**RESPONSE TO REQUEST FOR INFORMATION - DA8240  
LUNA PARK SYDNEY - WILD MOUSE TENANCY FITOUT AND EXTERNAL WORKS**

This letter has been prepared by JBA on behalf of Luna Park Sydney Pty Ltd (the Applicant) in relation to the proposed fitout works at the existing kitchen, servery and function space within the ground floor of the Wild Mouse Building, Luna Park (the site). The Development Application (DA 8240) was lodged with the Department of Planning and Environment in February 2017.

EXISTING + PROPOSED ELEVATION WEST

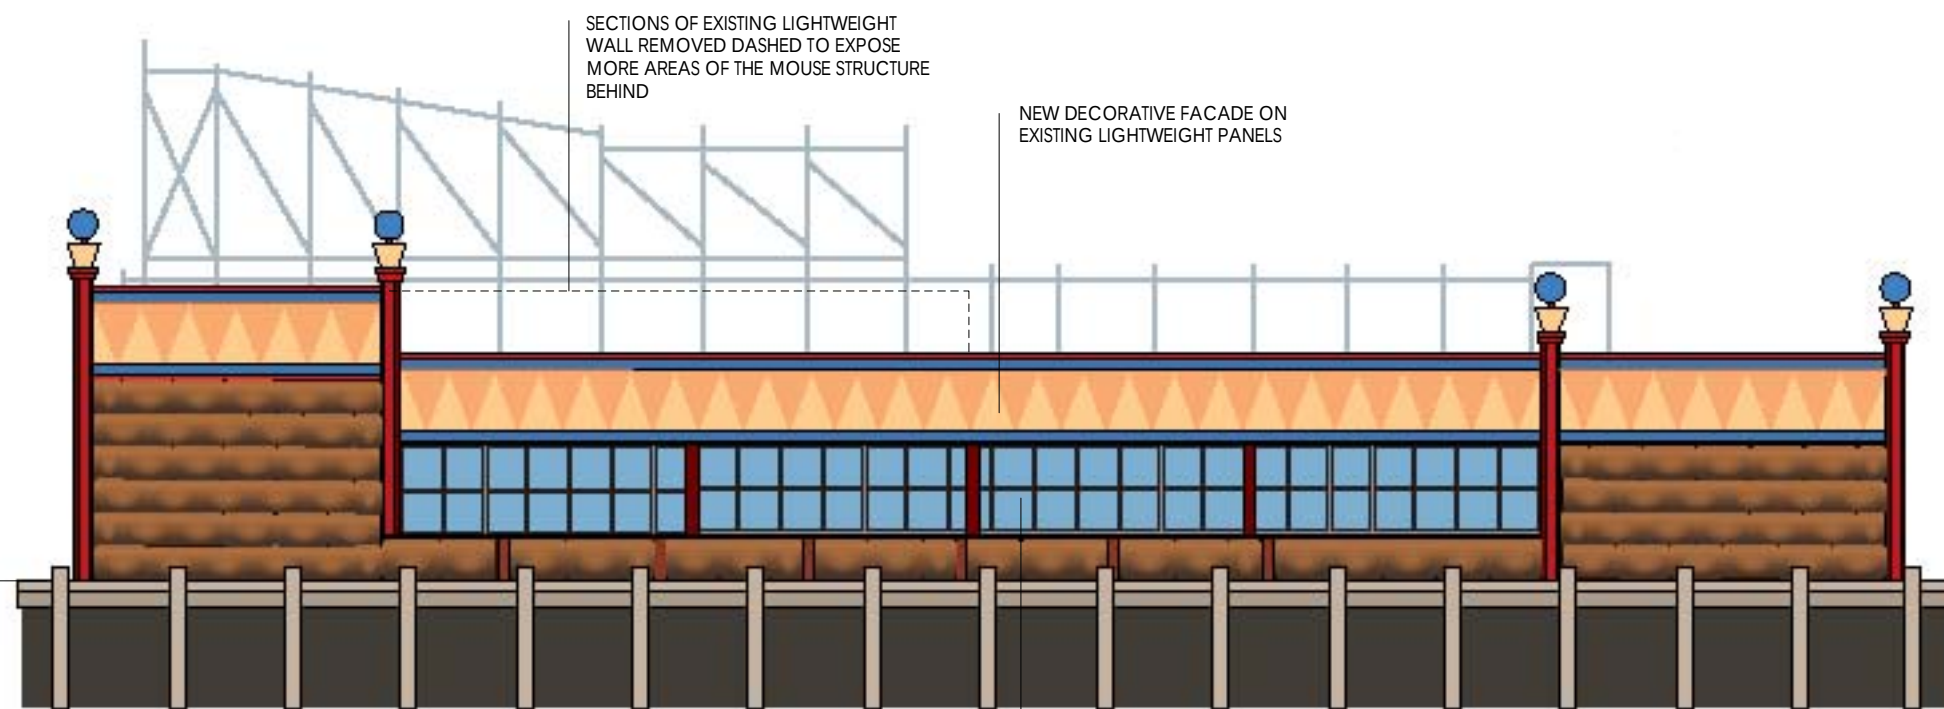
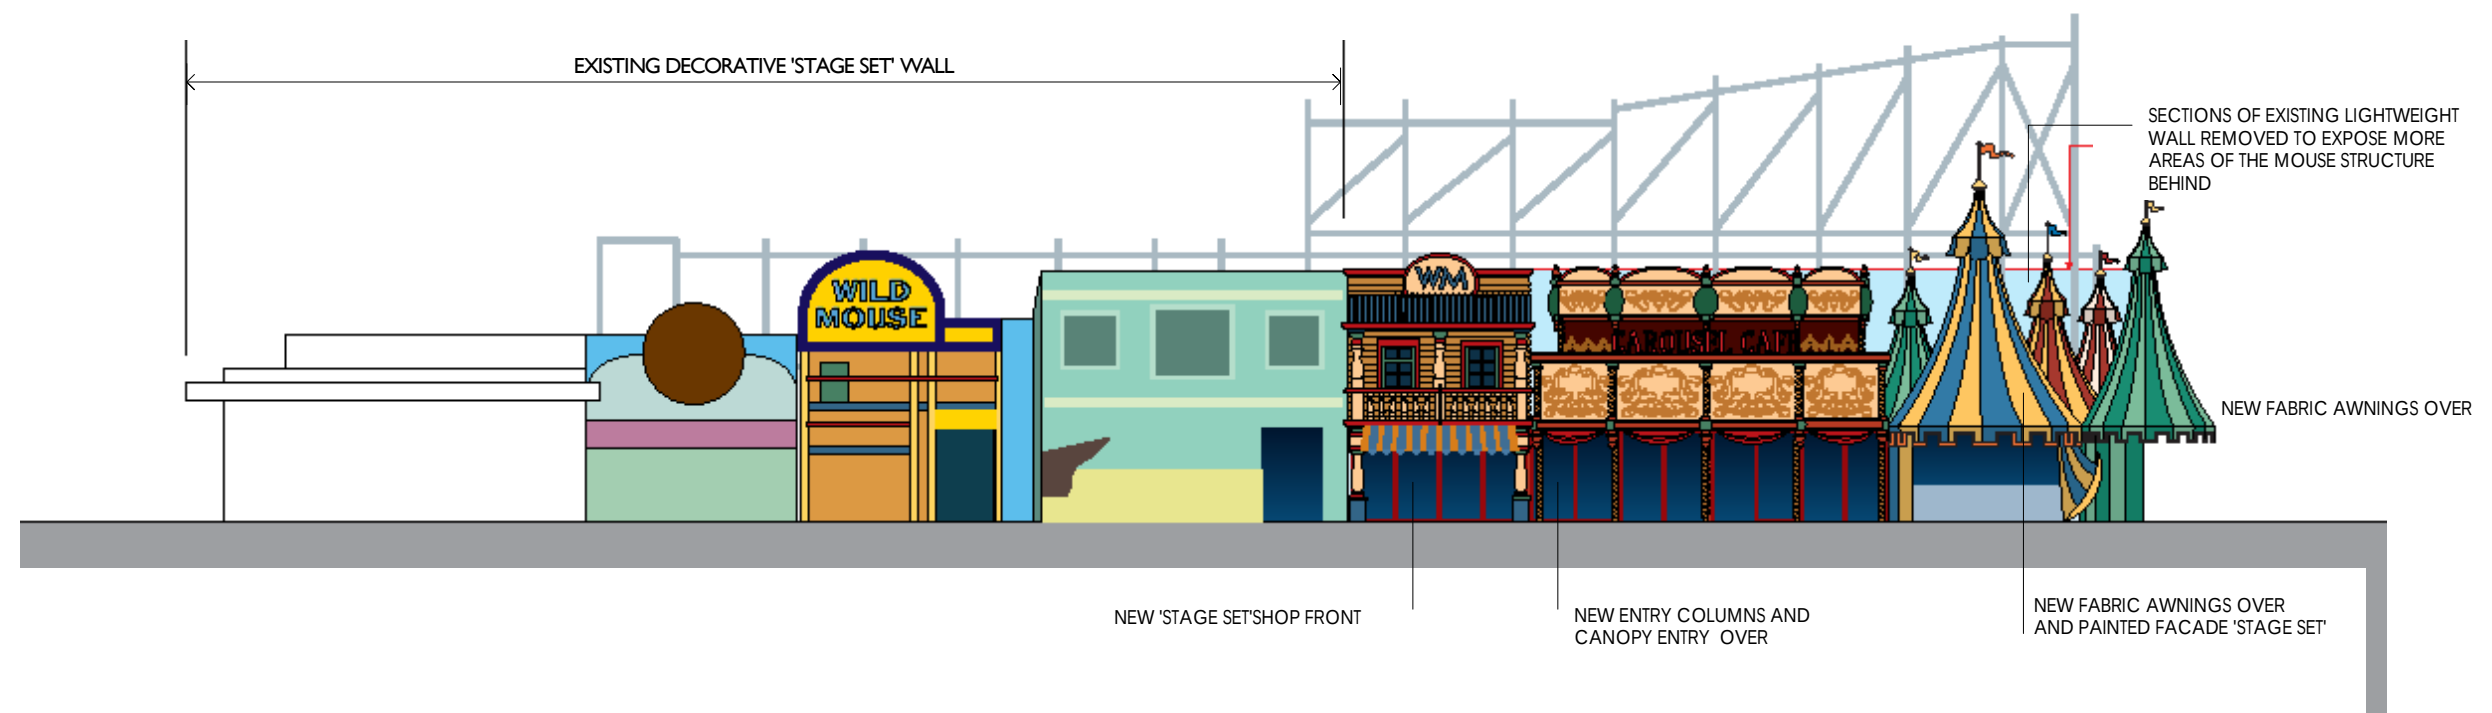
| Issue Raised                                                                                                                                                                             | Response                                                                                                                                                                                                                                                                                                                                                                                                                                                                                                                                                                                                                                                                             |
|------------------------------------------------------------------------------------------------------------------------------------------------------------------------------------------|--------------------------------------------------------------------------------------------------------------------------------------------------------------------------------------------------------------------------------------------------------------------------------------------------------------------------------------------------------------------------------------------------------------------------------------------------------------------------------------------------------------------------------------------------------------------------------------------------------------------------------------------------------------------------------------|
| The western façade of the Wild Mouse Building should not encroach onto the public waterfront boardwalk more than that existing.                                                          | The proposal does not seek to extend the Wild Mouse Building onto the public boardwalk. The proposed alterations to the western façade are decorative only.                                                                                                                                                                                                                                                                                                                                                                                                                                                                                                                          |
